Application No: EP/163/21/HH
Site Address: 4 Selhurst Close East Preston BN16 2SR
Description of works: Single storey front extension, conversion of integral garage and new detached garage.

Thank you for your internet representation made on 13th December 2021 which has been recorded as an objection with the comments as follows:

Drawing Name
Garage - Proposed

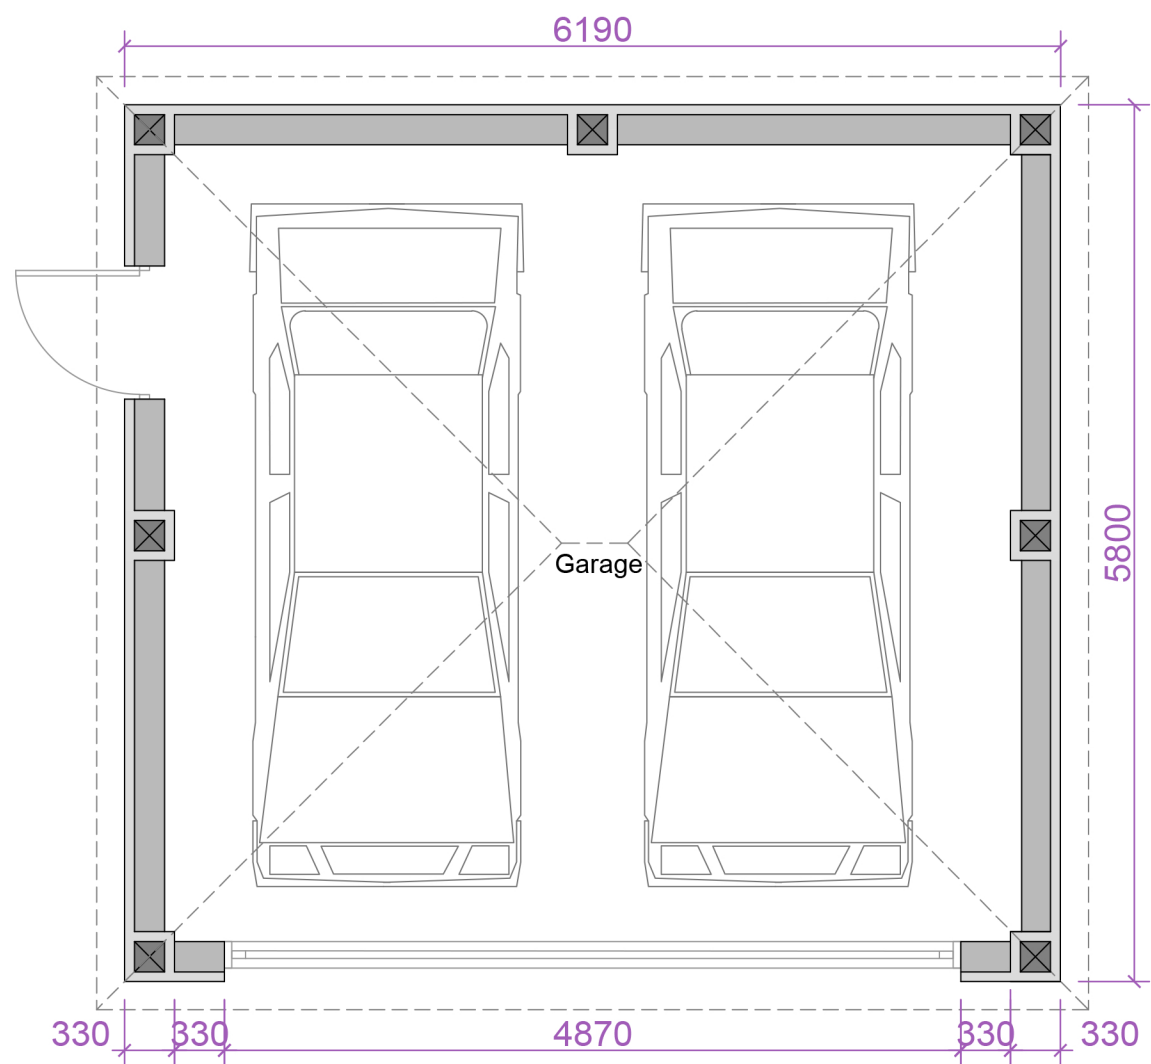
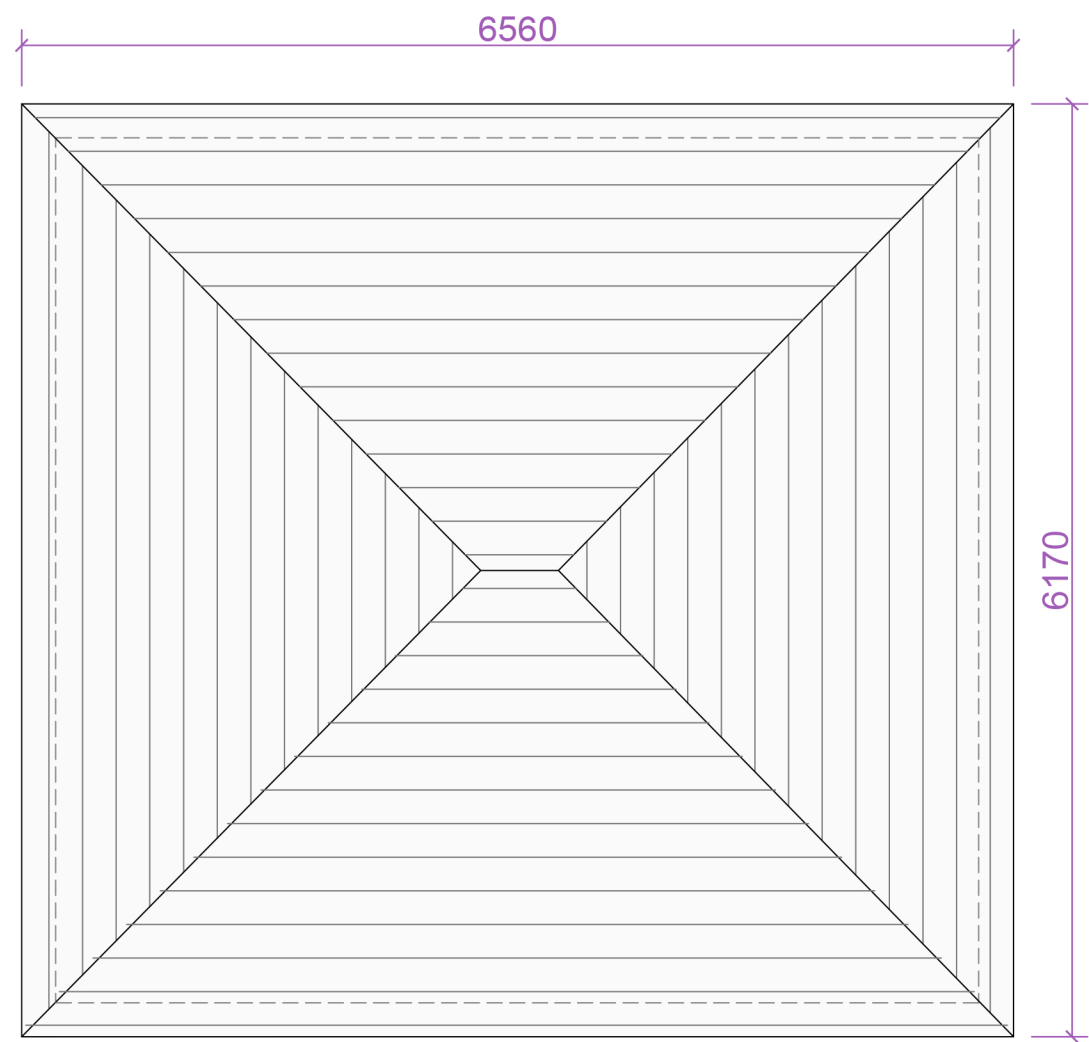
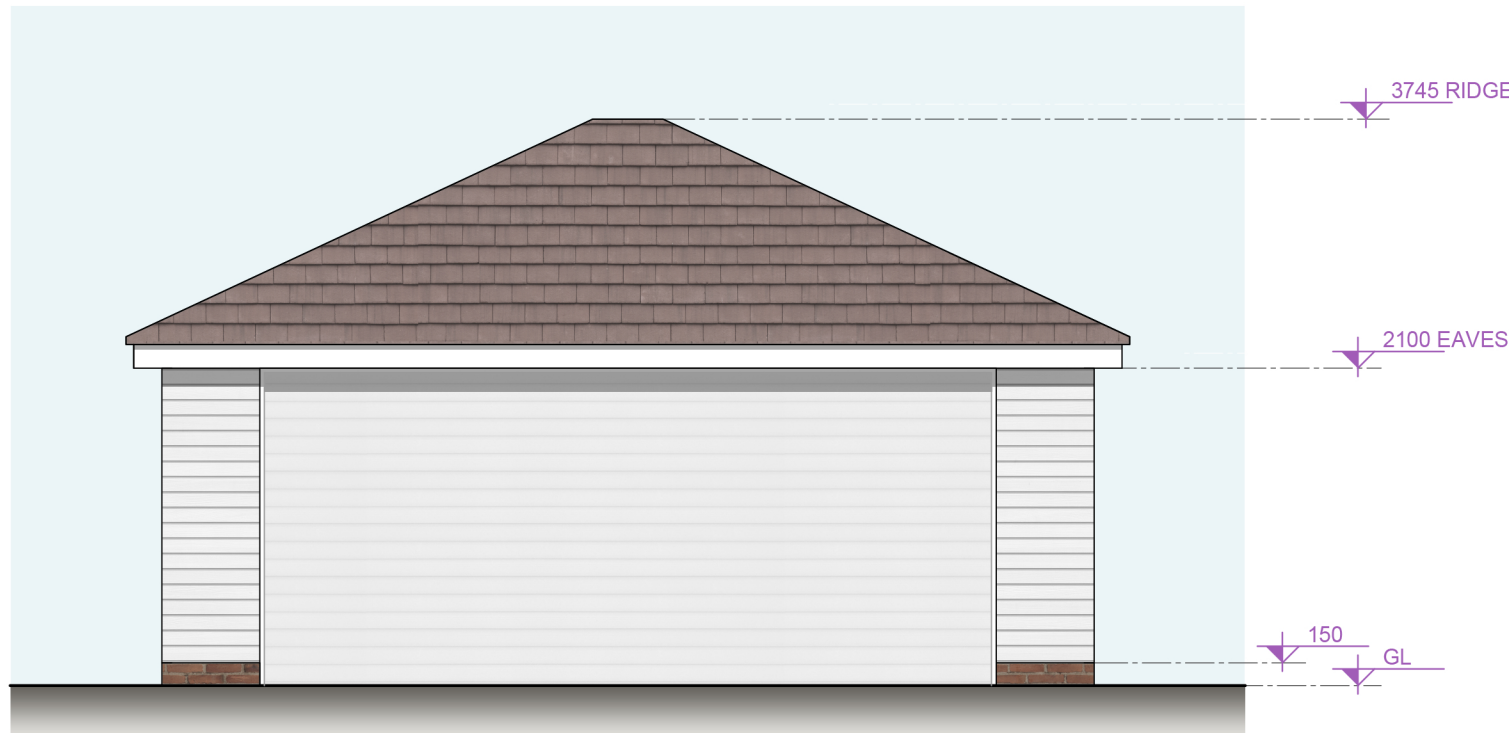
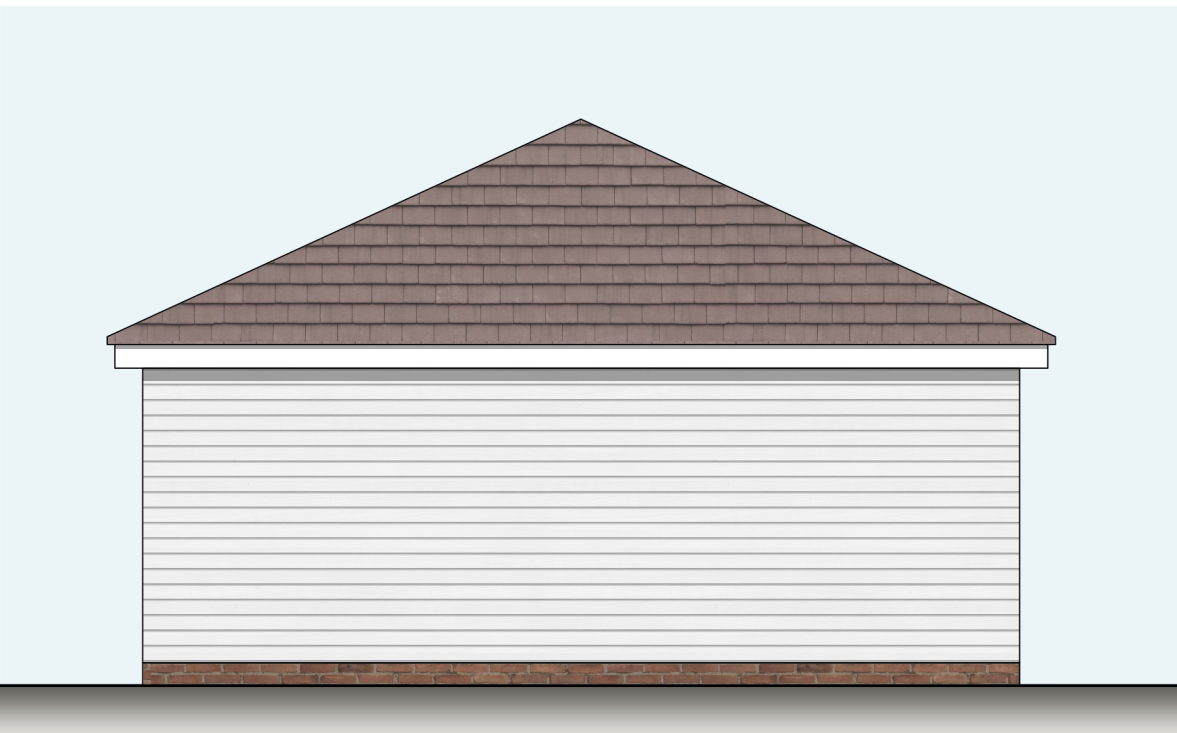
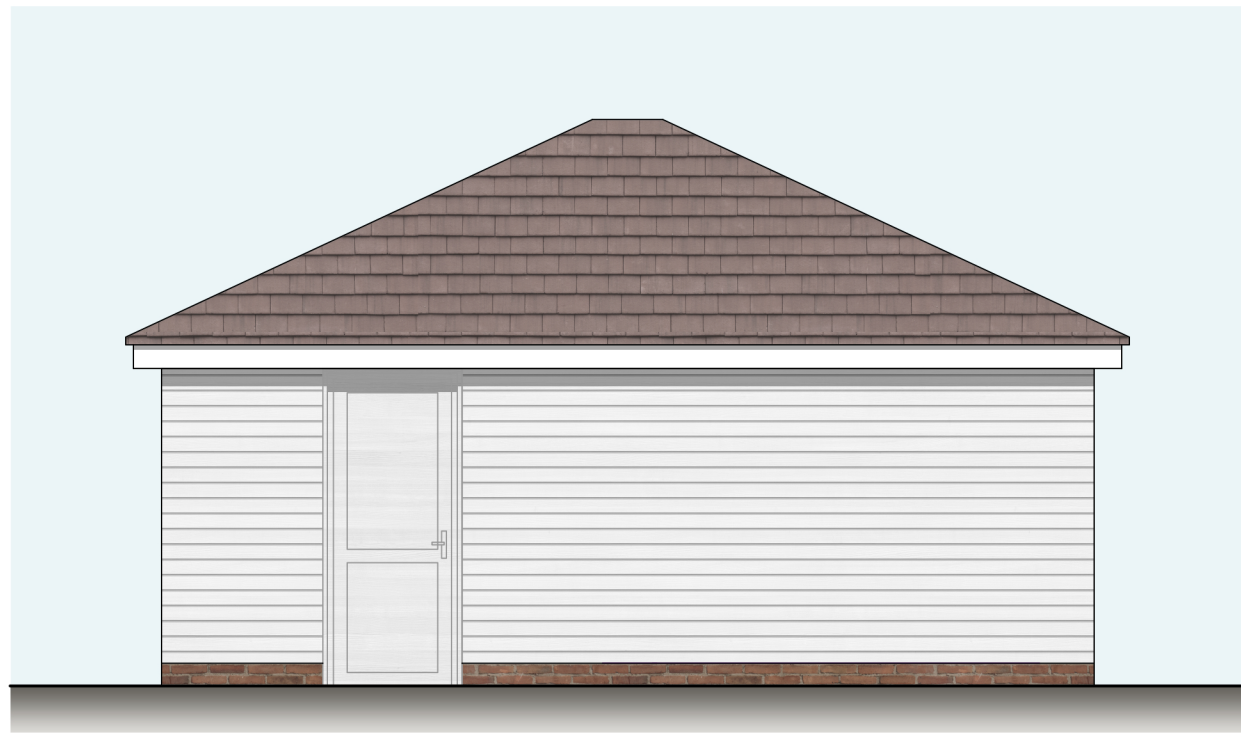
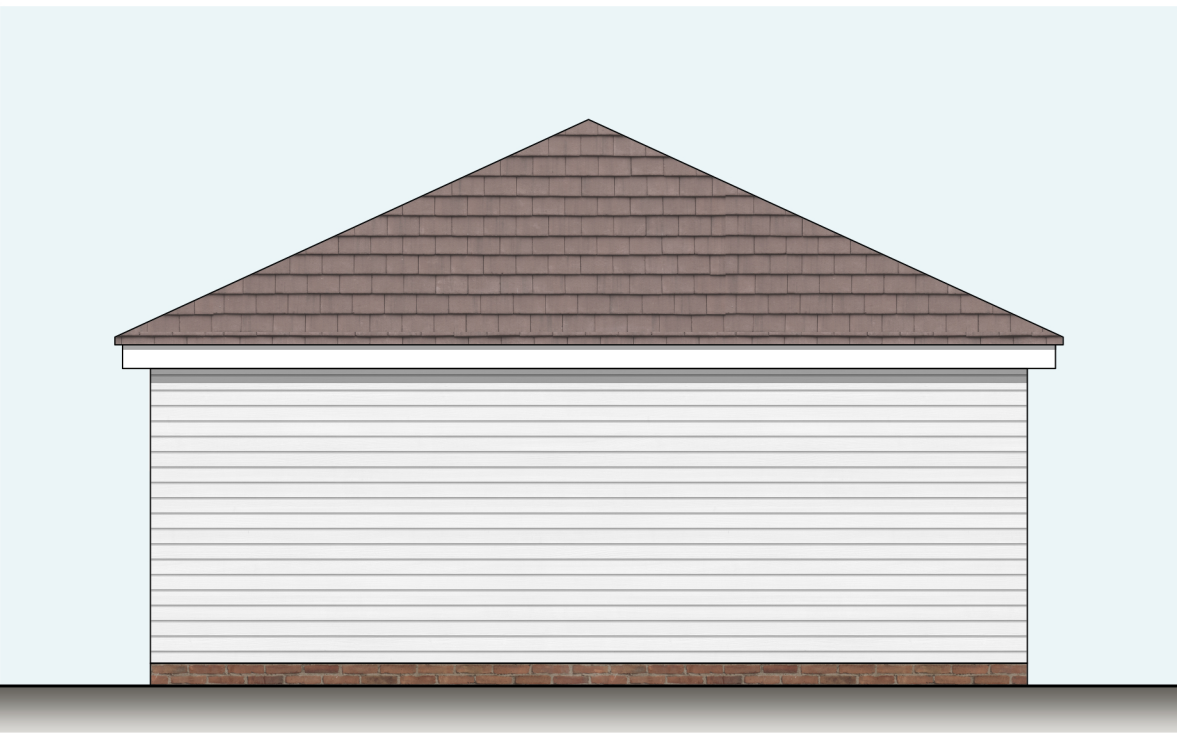
The objection is to the building of a new detached garage so far in front of the existing building line of the property on the grounds that the appearance and scale of a large frontal garage building is completely out of keeping with the open planning ethos of the estate, and in particular of the close itself, where properties nos 2 to 7 are all built to a semi-circle building line with open frontages.
